**From:** Gregg, Robert <Robert.Gregg@lancashire.gov.uk>  
**Sent:** 29 October 2018 12:03  
**To:** Rebecca Bowers  
**Cc:** planning; LHS Customer Service  
**Subject:** APP. 3/2018/0790 - 11 GREEN PARK, WHALLEY

### **Application for a proposed two storey side extension.**

Client Mr Charles Cocks
Job Title 11 Green Park Whalley Clitheroe BB7 9TJ
Drawing Title Proposed Floor Plans and Elevations
Scale Various @ A1
Date August 2018
Drawn Craig Harrison

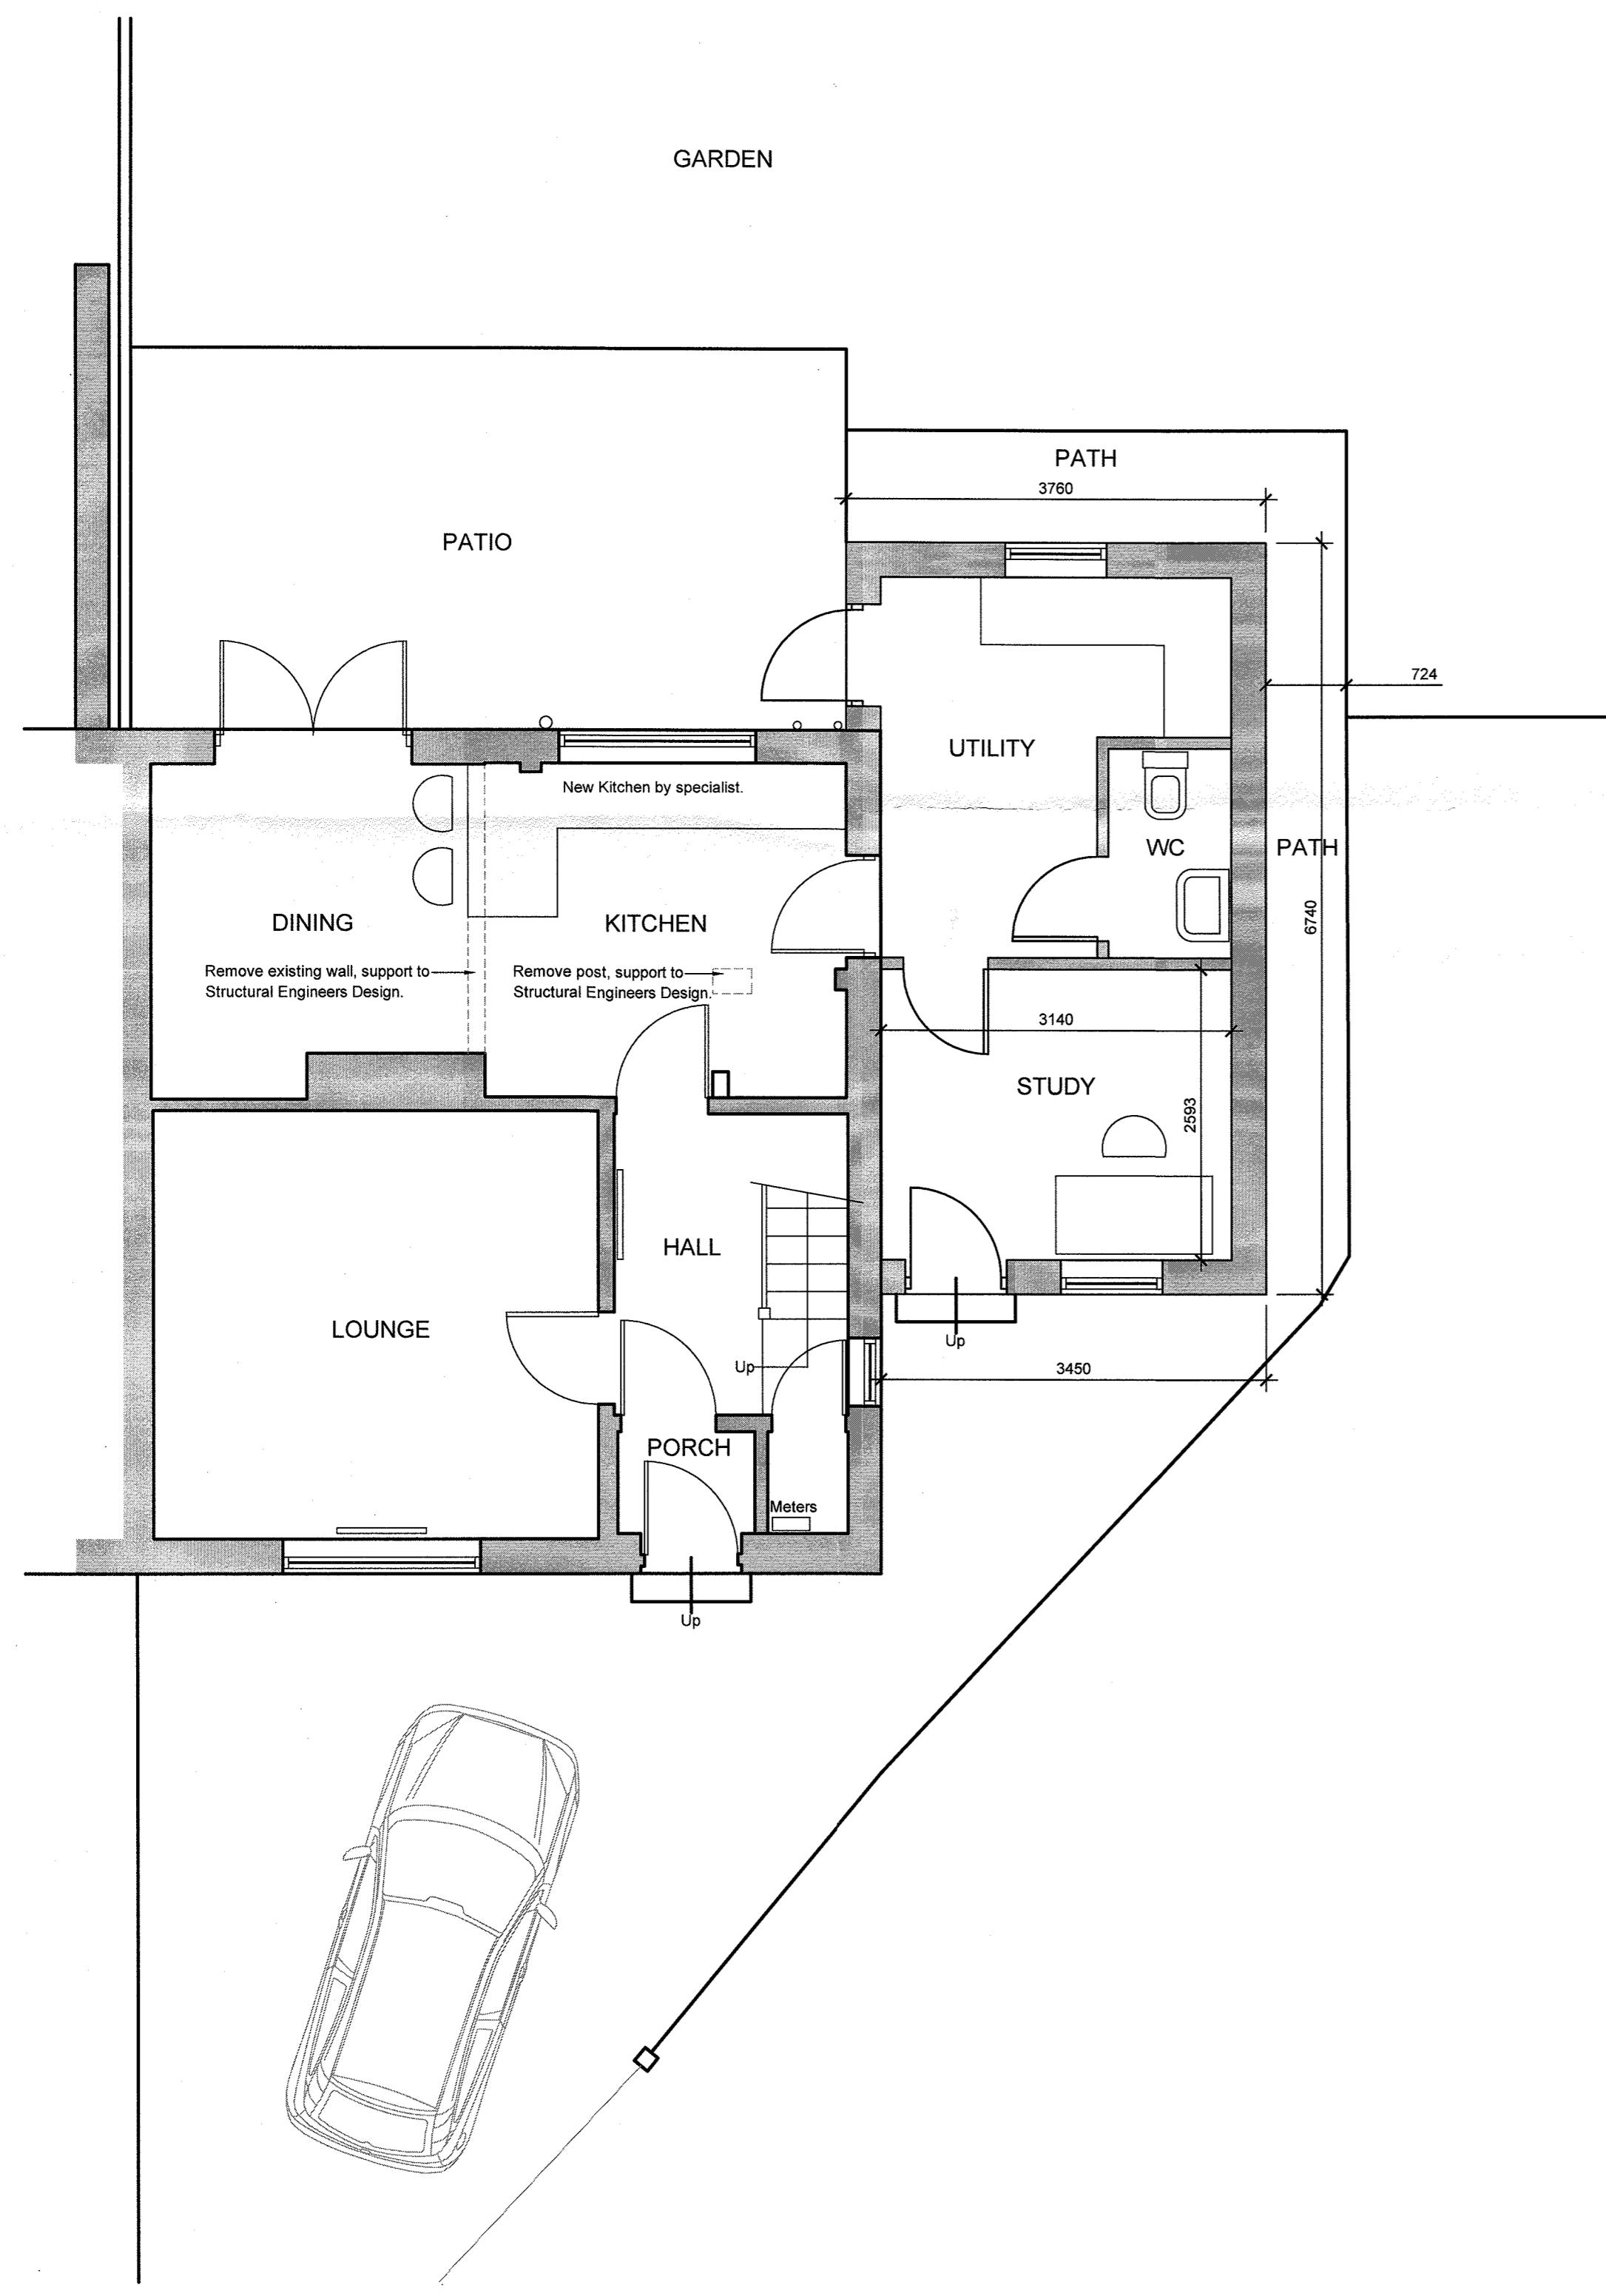
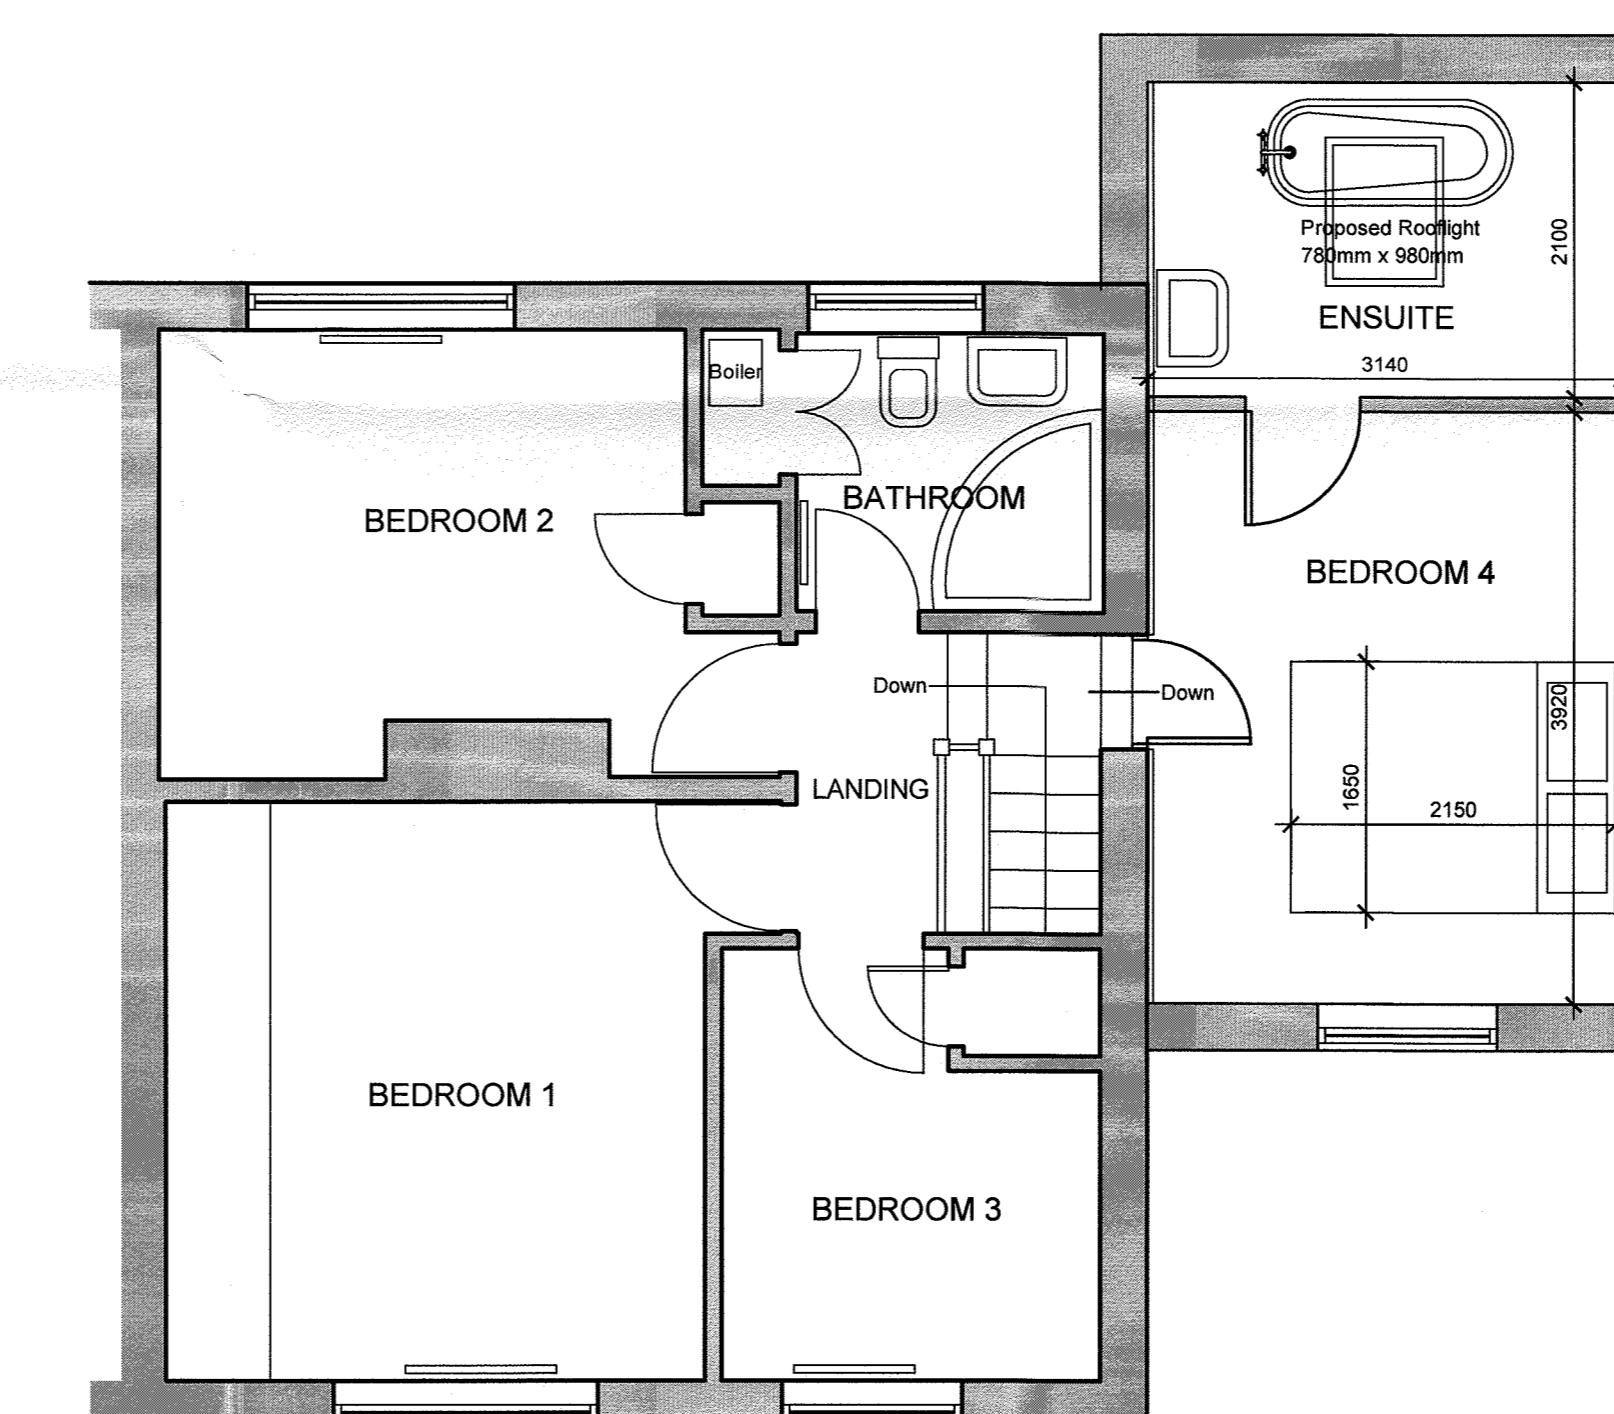
The submitted plans indicate that there will be an increase in the number of bedrooms from 3-4 bedrooms and as such, based on LCC's maximum parking standards the provisional use of 3 parking spaces would be sufficient for this proposal. However, I would need to see how this can be achieved.

Parking is already limited within the vicinity of the dwelling and I would require further clarification on the parking arrangements being set out for the proposal,

The dwelling is situated on a cul-de-sac within a turning head at the bottom of Green Park. There is already a number of cars which are being parked within the turning head and are also being parked on the footway.

I would therefore ask that the plans be revised.
